211813 CFAA

## Modification 7 Precinct Village and Carpark (SSD-9835-Mod-7)

### Technical Note on Flooding in Response to DPE Comments

Figure 6: Flood mitigation measures incorporated in design

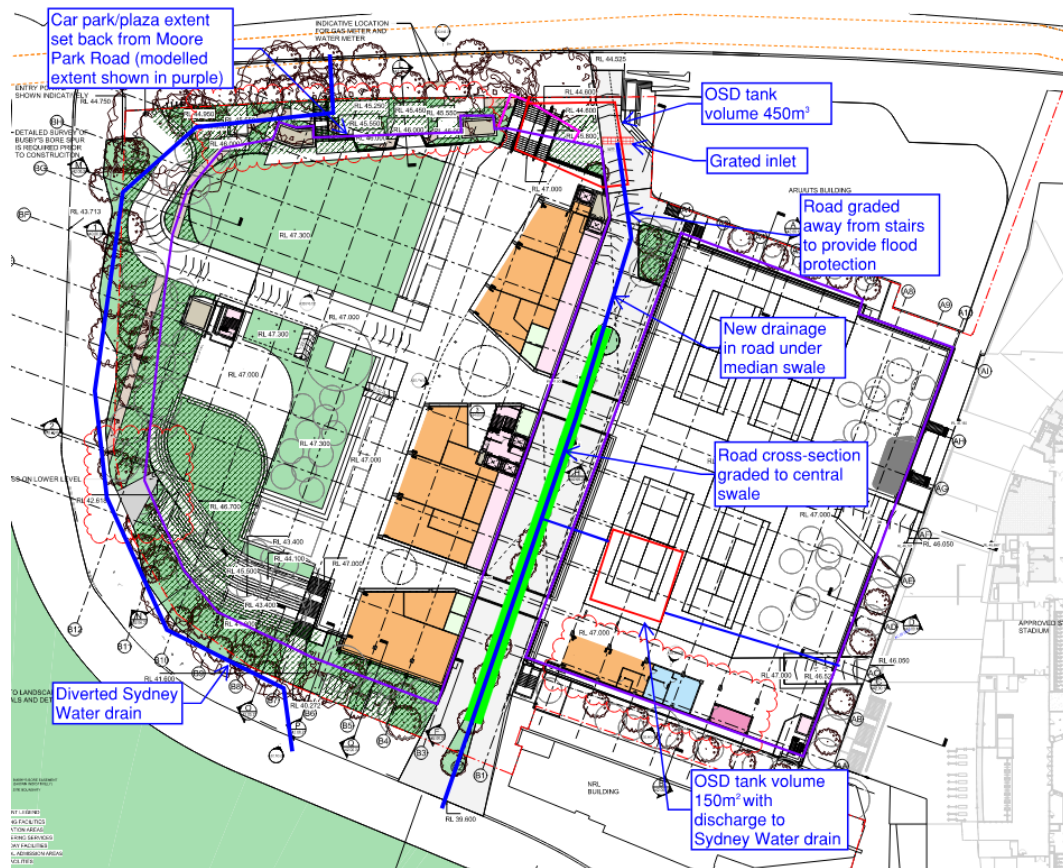
- the RtS does not demonstrate that “no worsening of hazard on the central driveway” has been achieved, but in fact indicates the opposite. EES therefore strongly recommends that clear documentation is provided to justify this conclusion.

EES does not agree that the required design solutions to manage and mitigate the impacts of flooding should be delayed until the detailed design of the proposal is finalised.

It is standard practice to provide evidence that the design solution achieves the required objectives. EES considers that an updated report should be produced, documenting the new design solution, and including updated figures, is required to appropriately assess the potential for and severity of flood impacts.

Section 4.0 provides details of the proposed flood mitigation design solution and confirms that there are no significant impacts associated with the development. Additional figures have also been incorporated throughout this report to show the existing and proposed flooding together with any impact associated with the development.

Section 4.0 confirms that flood gates have now been removed from the proposed flood mitigation measures with floor levels and basement crest levels amended to achieve the required Flood Planning Levels.

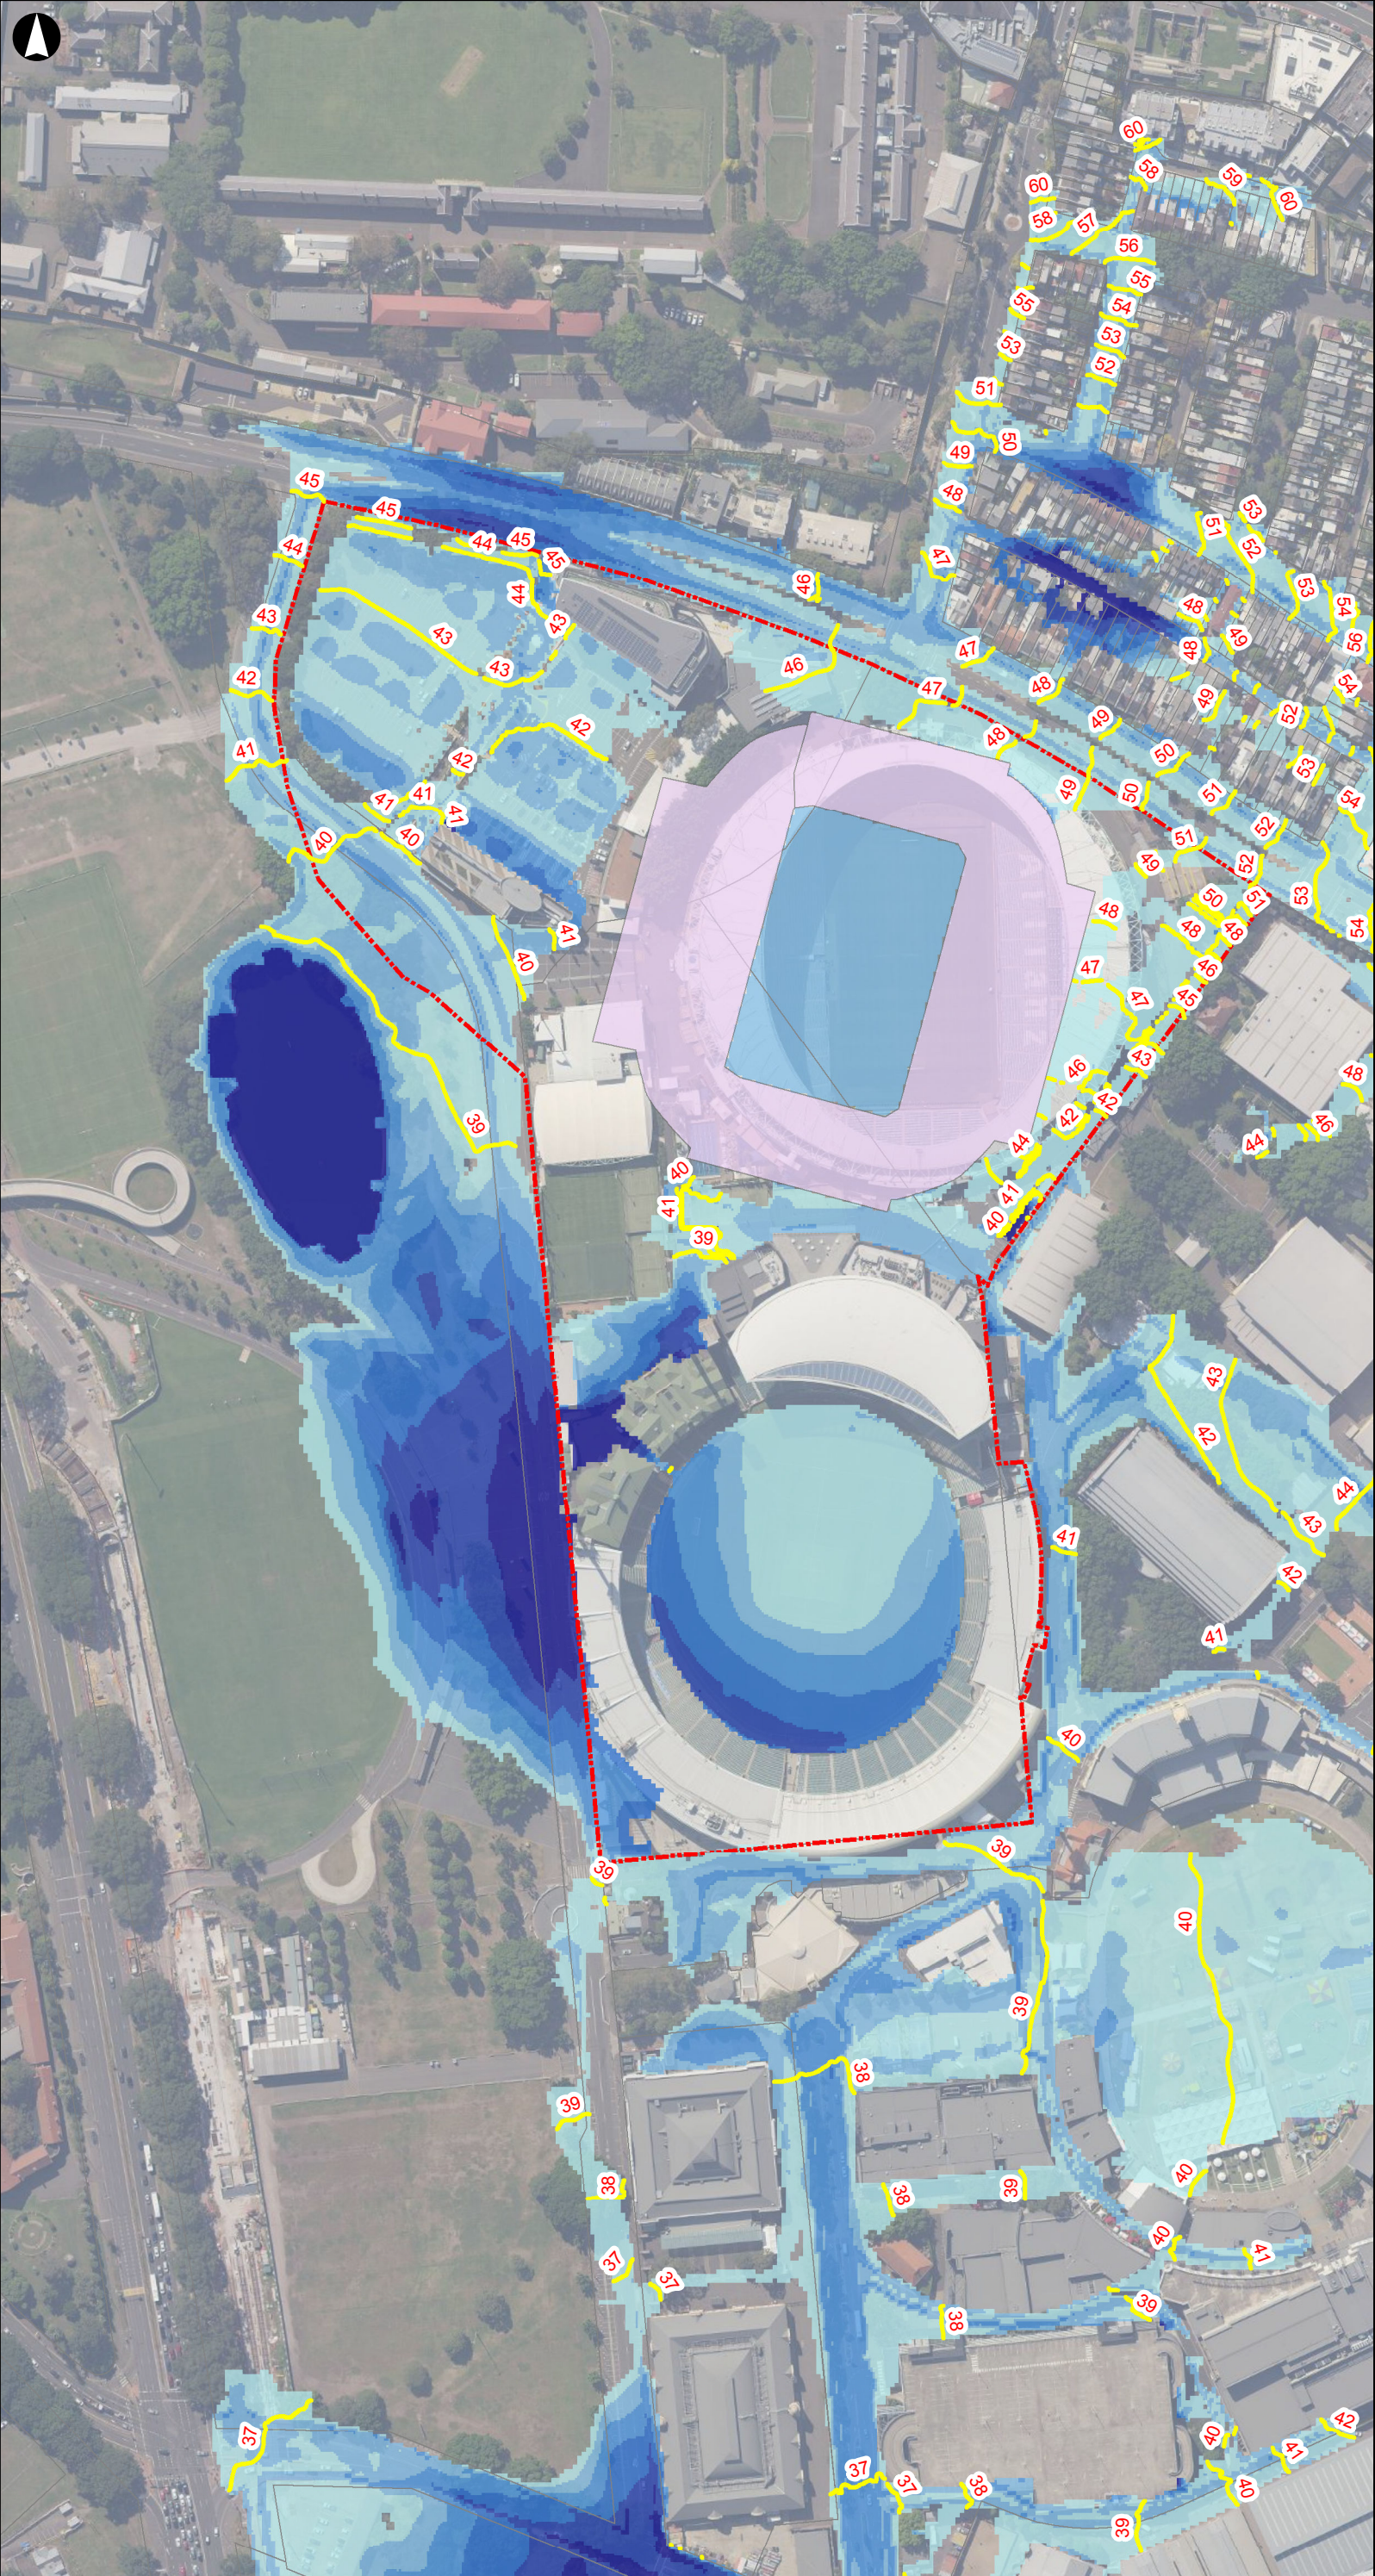
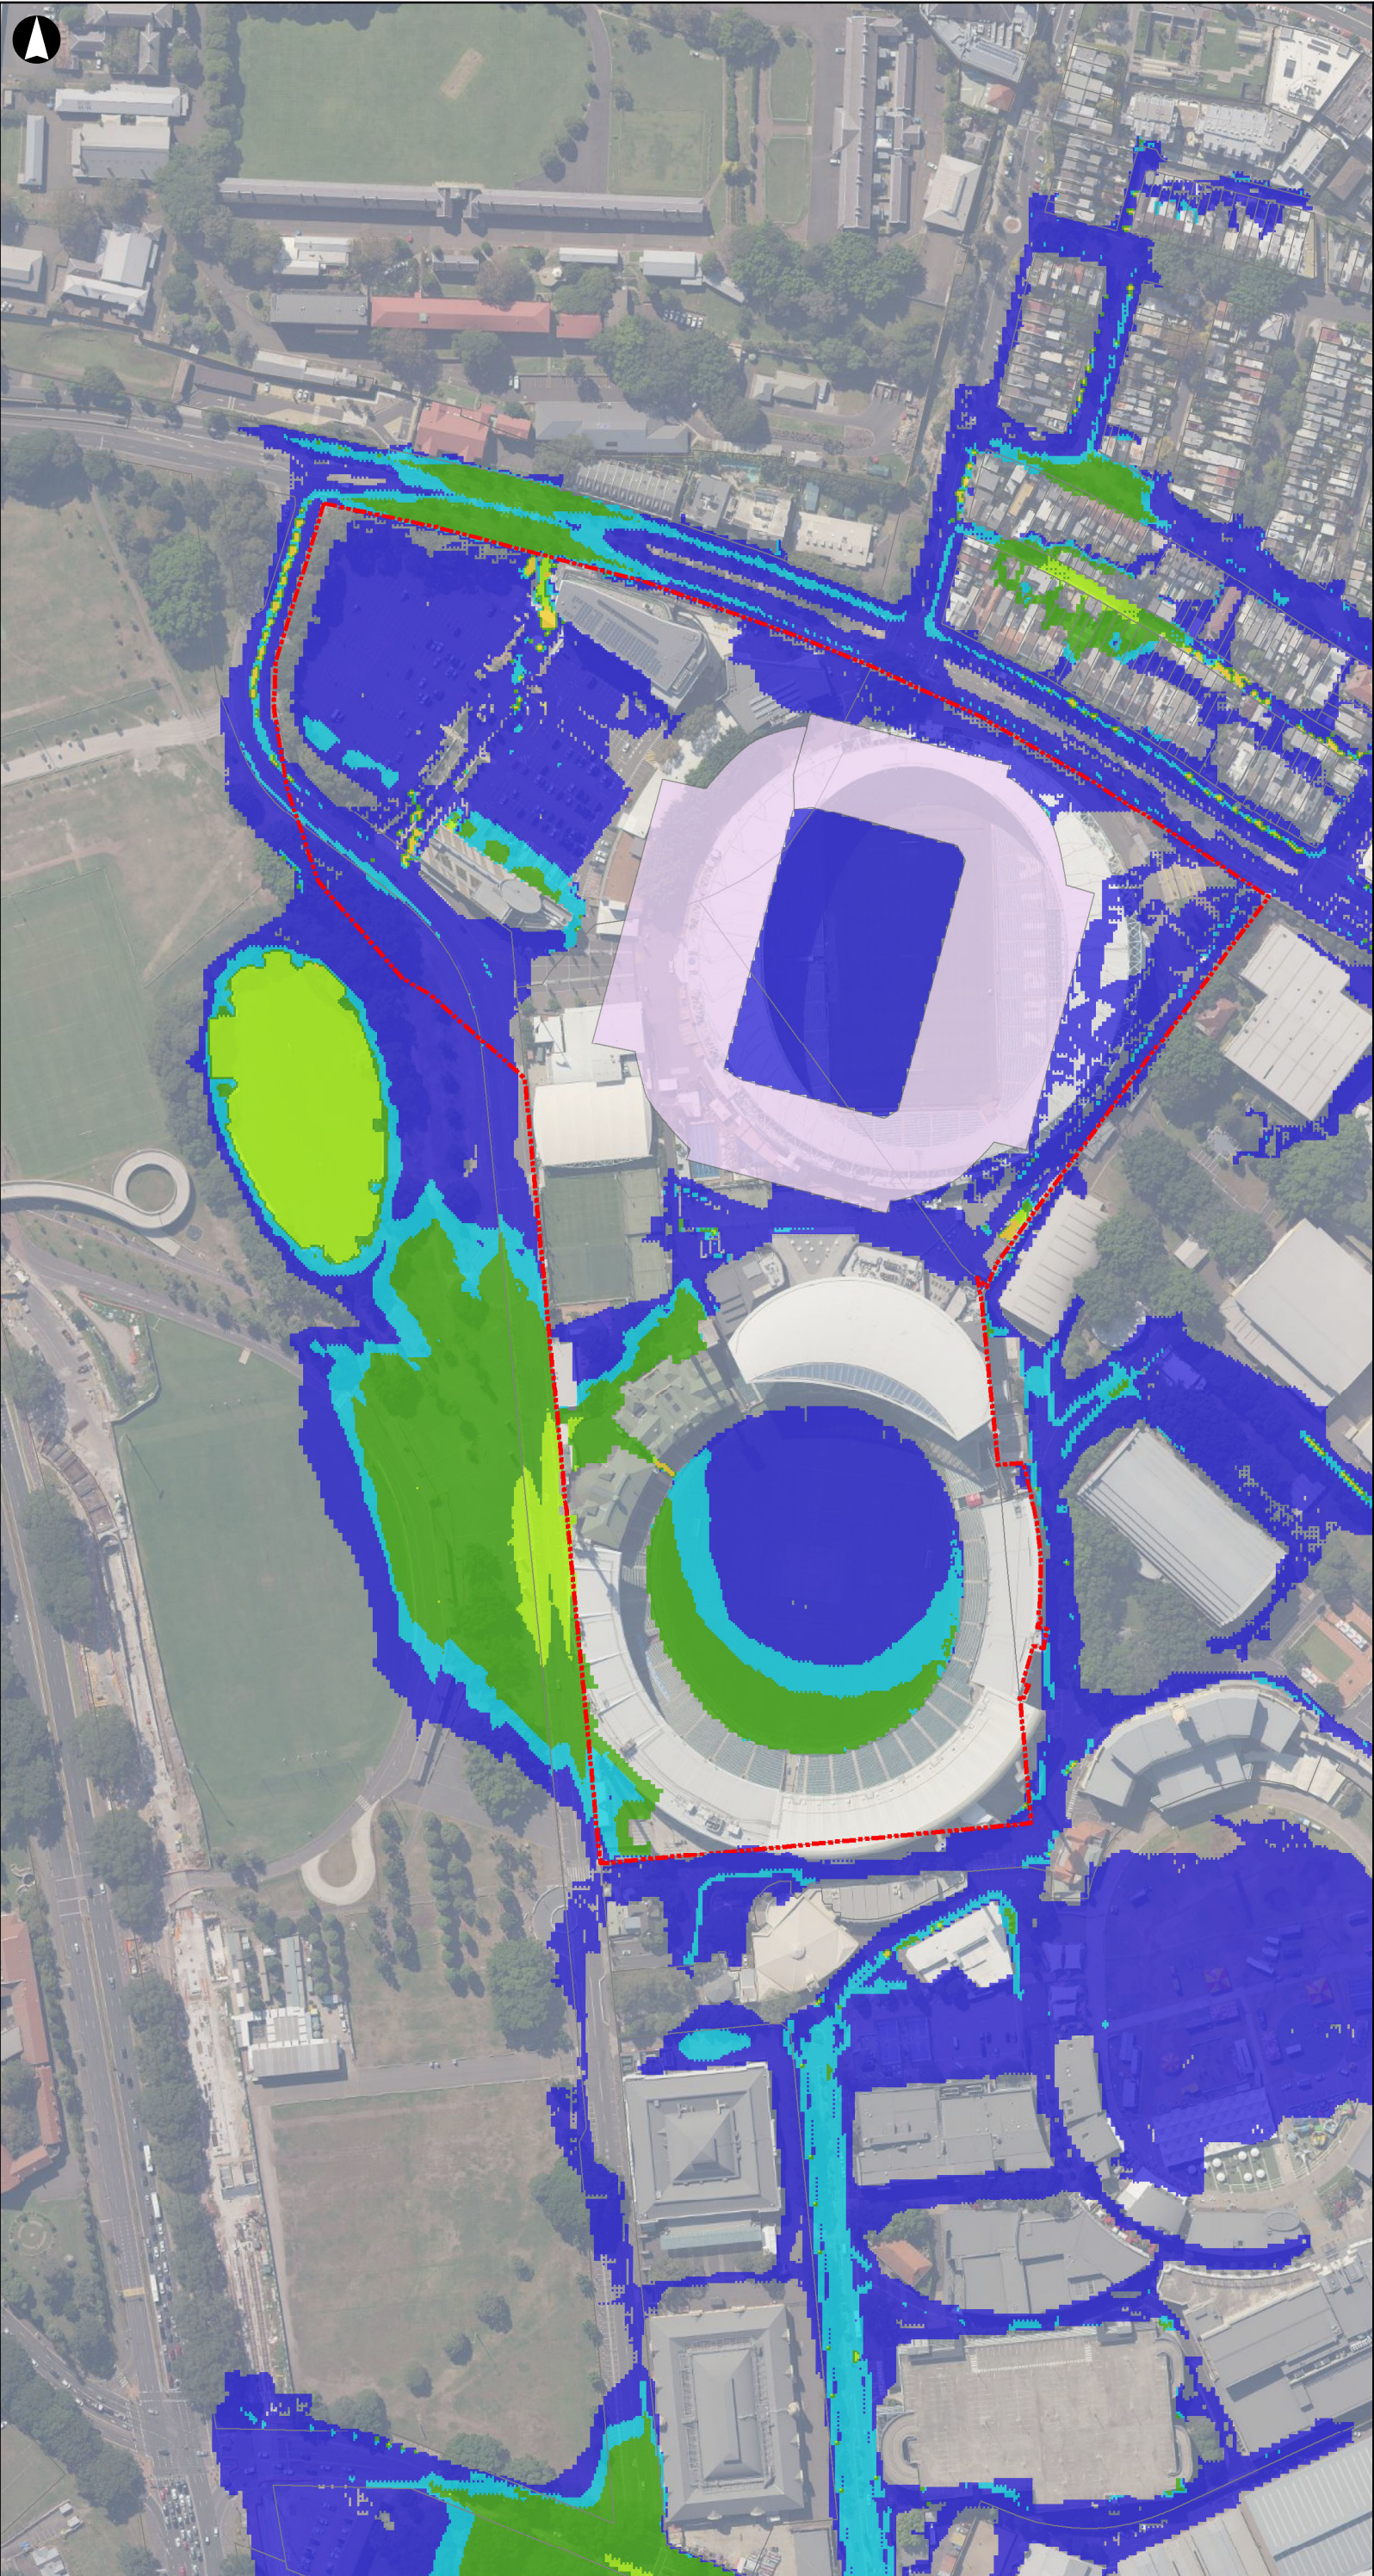
- there are only three figures presented in Appendix G, presumably showing hazard. The RtS states afflux figures were provided, but they are not available at Appendix G. Figures as per the original report should be updated, including depth/level and afflux

Additional figures have been included in section 4.0 that show flood levels, depths, hazard and afflux associated with the proposed development.
